Application No: Y/39/20/RES  
Site Address: Land at Street Building North End Road Yapton BN18 0DT  
Description of works: Approval of reserved matters following outline consent Y/49/17/OUT & Section 73 permission Y/13/19/PL for 45 No. dwellings & associated works. This application may affect the setting of a Listed Building.

Thank you for your internet representation made on 28th May 2020 which has been recorded as support with the comments as follows:

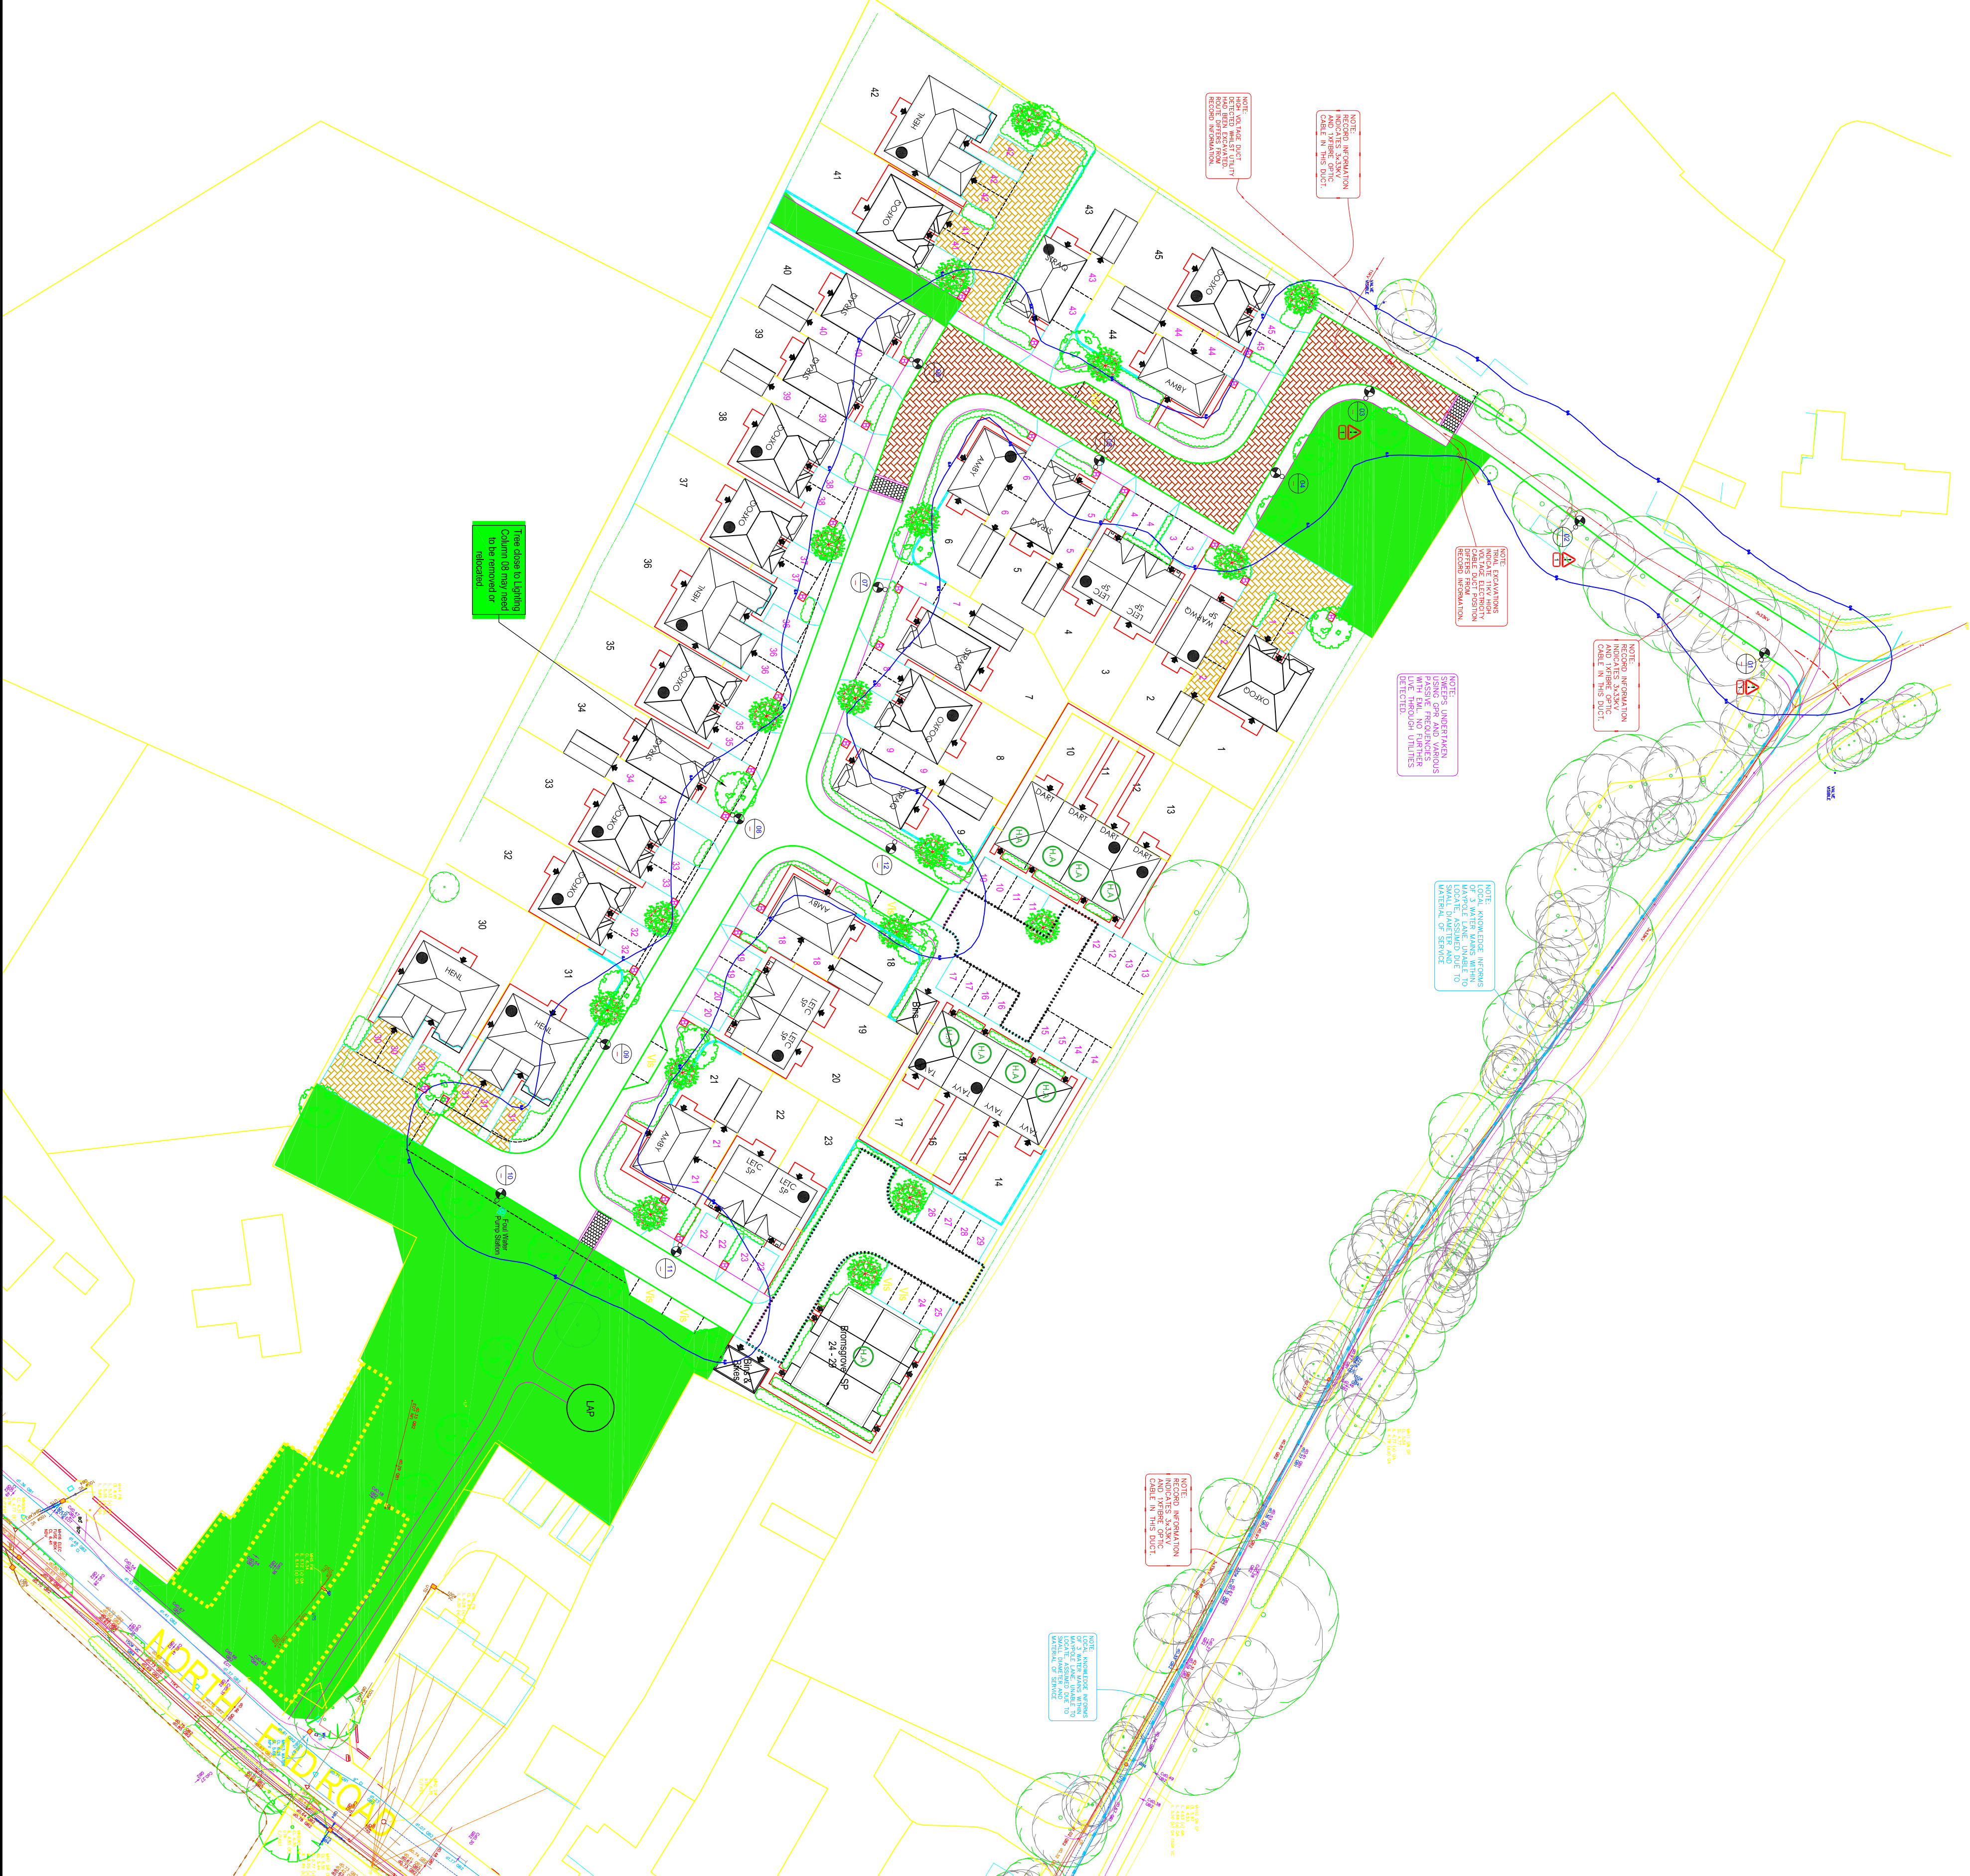
4. YPC have concerns with the remoteness of the LAP from the main housing and would prefer it to be more central to the scheme.
5. Lighting. Street lighting must respect the dark nights in this area and ensure that there is limited 'bleed' impacting the nearby housing on North End Road. Conditions restricting hours of operation should be implemented along with limits on lux levels and ensuring all lighting is capped and low to ensure down-lighting

only.
